Rezoning Transportation Analysis

Petition Number: 2020-014

Revision Log:

Date	Description
02-24-20	First Review
03-24-20	Second Review

PROJECT #: DATE: 3-16-2020
DRAWN BY: JB CHECKED BY: PC
TITLE: SITE PLAN
SHEET NO.: RZ-1

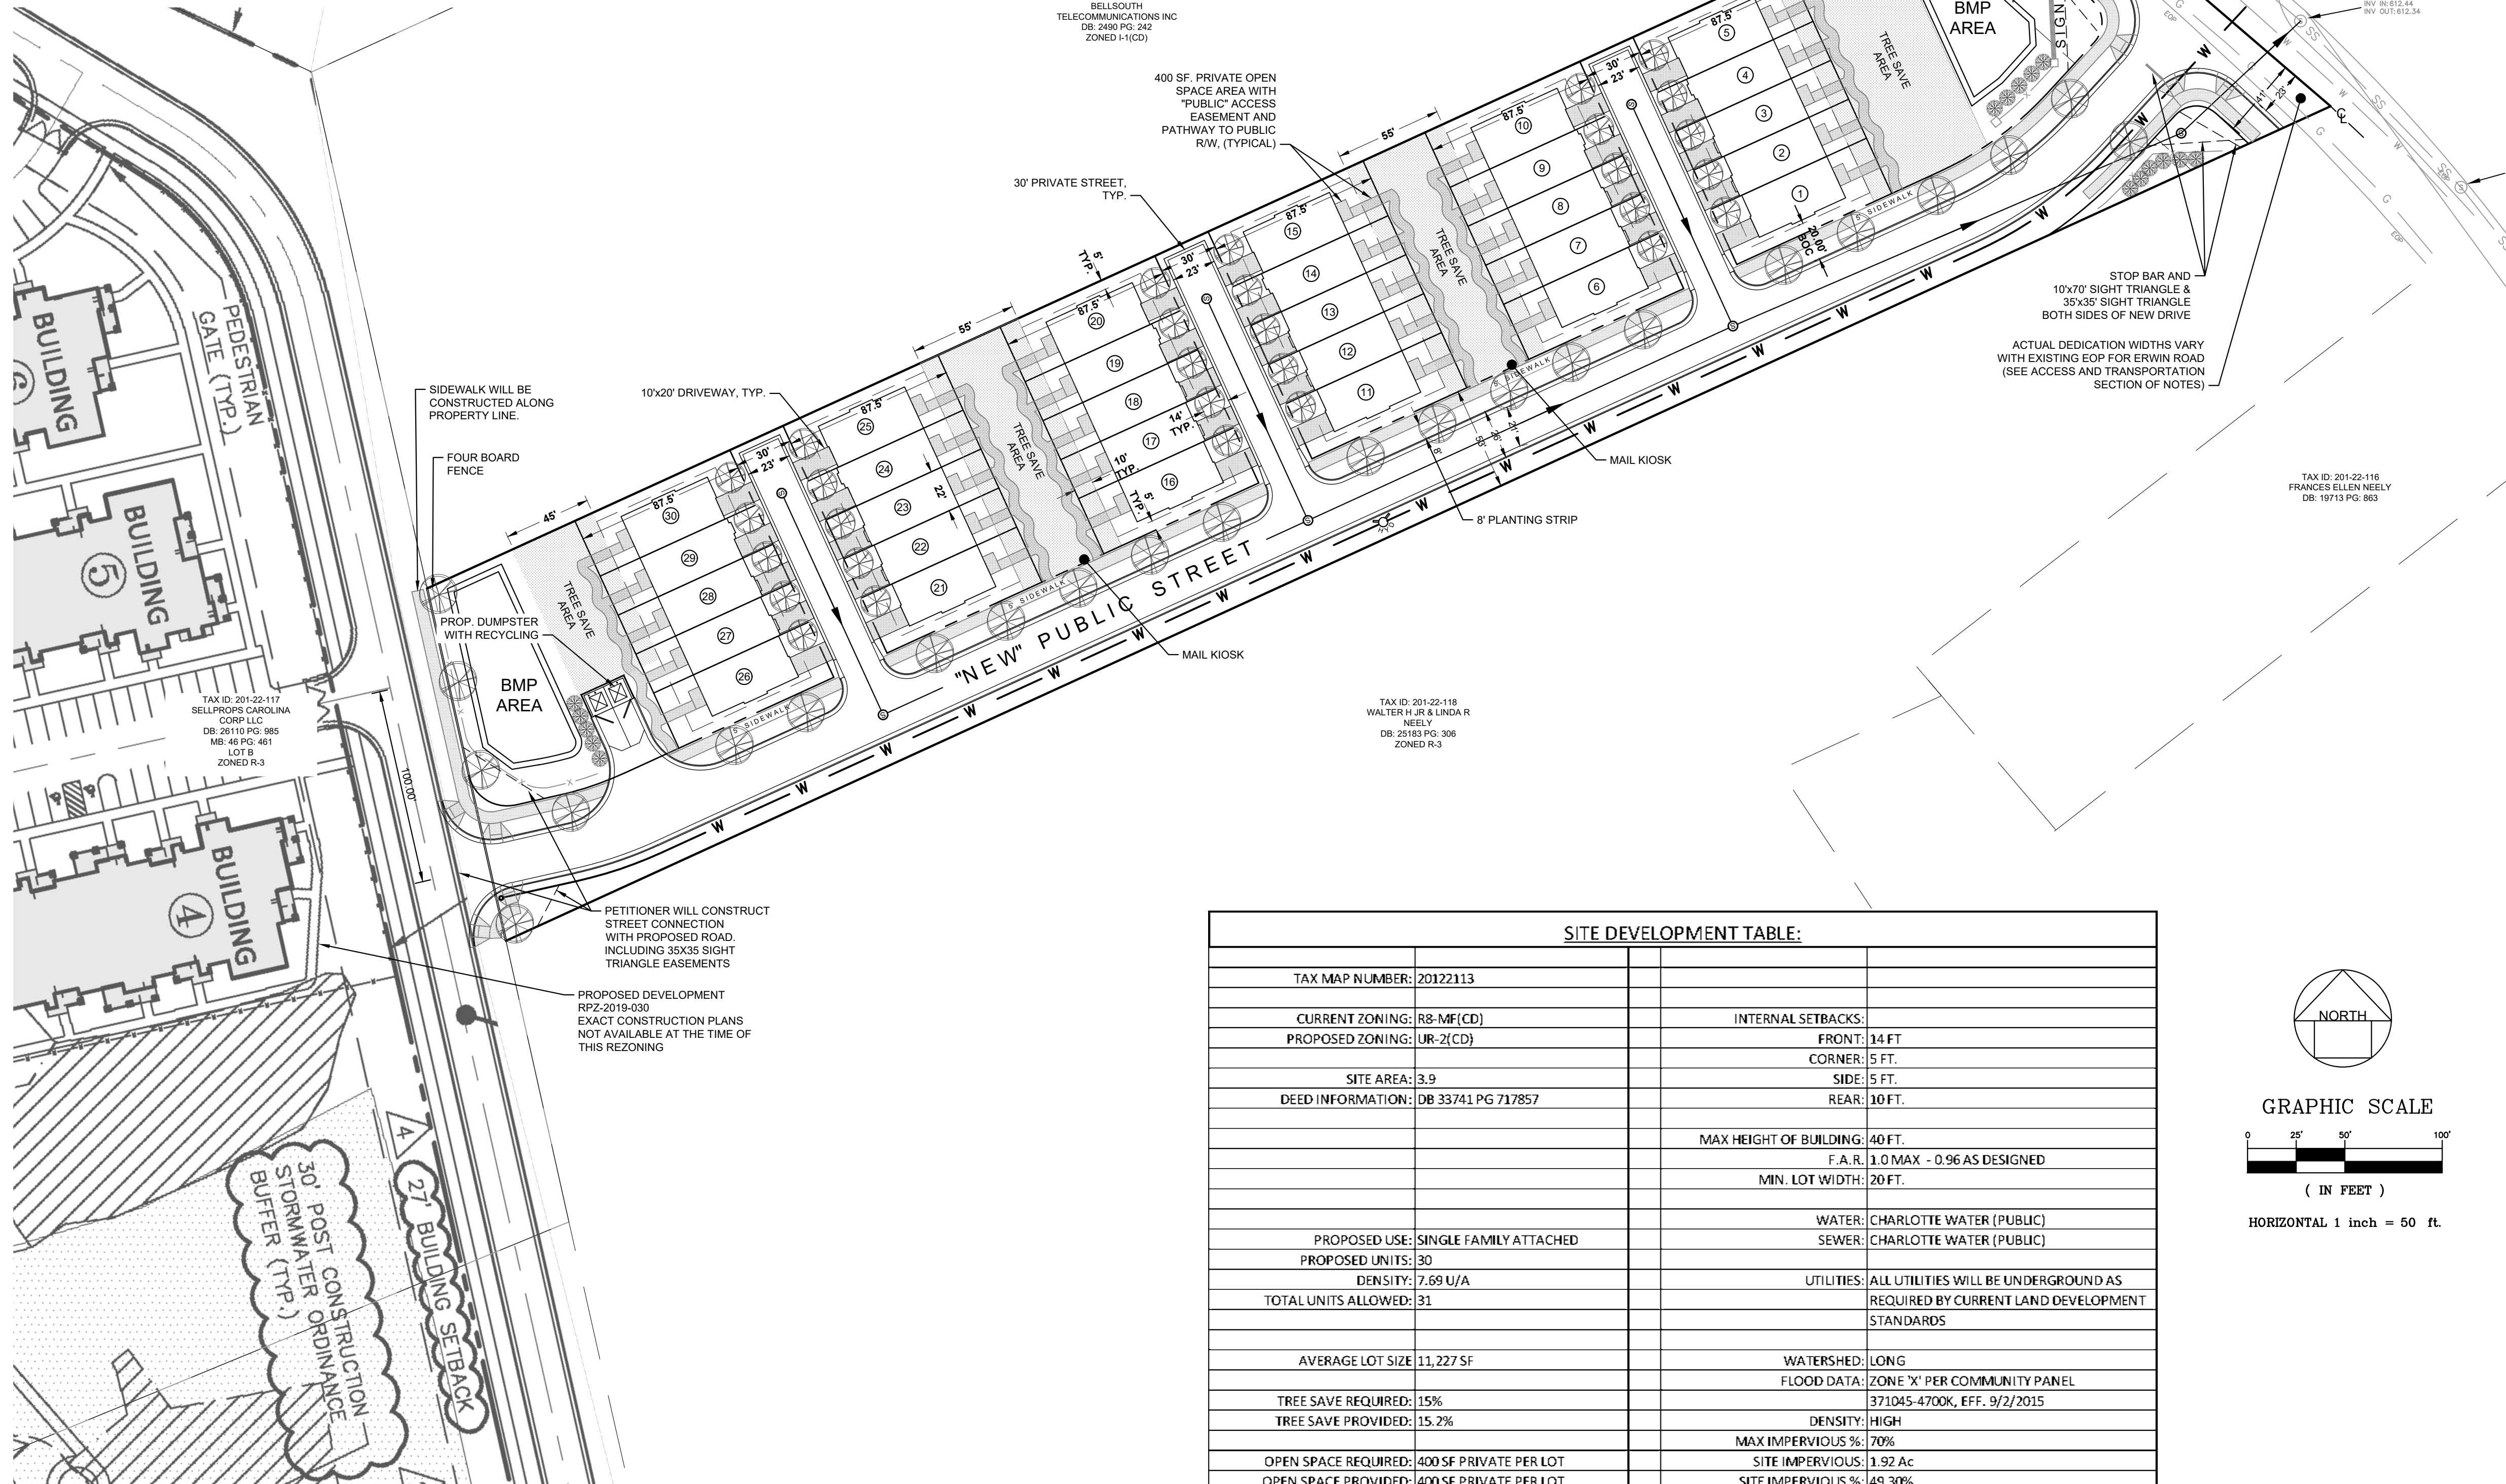
- a. **Erwin Road:** The future location of curb and gutter is 24 feet from centerline of the road. The petitioner should revise the site plan and commit to construct the curb and gutter at its ultimate location. The site plan should revise the site plan to label and dimension the curb and gutter from the road centerline. **Technical Clarification. 24 feet is measured from existing centerline to proposed back of curb. Please incorporate 24 feet into the proposed site plan.**

6. **Outstanding.** The petitioner should revise the site plan and conditional notes(s) to include a stop bar and stop sign at the proposed intersection of the "new" street & Erwin Road intersection.
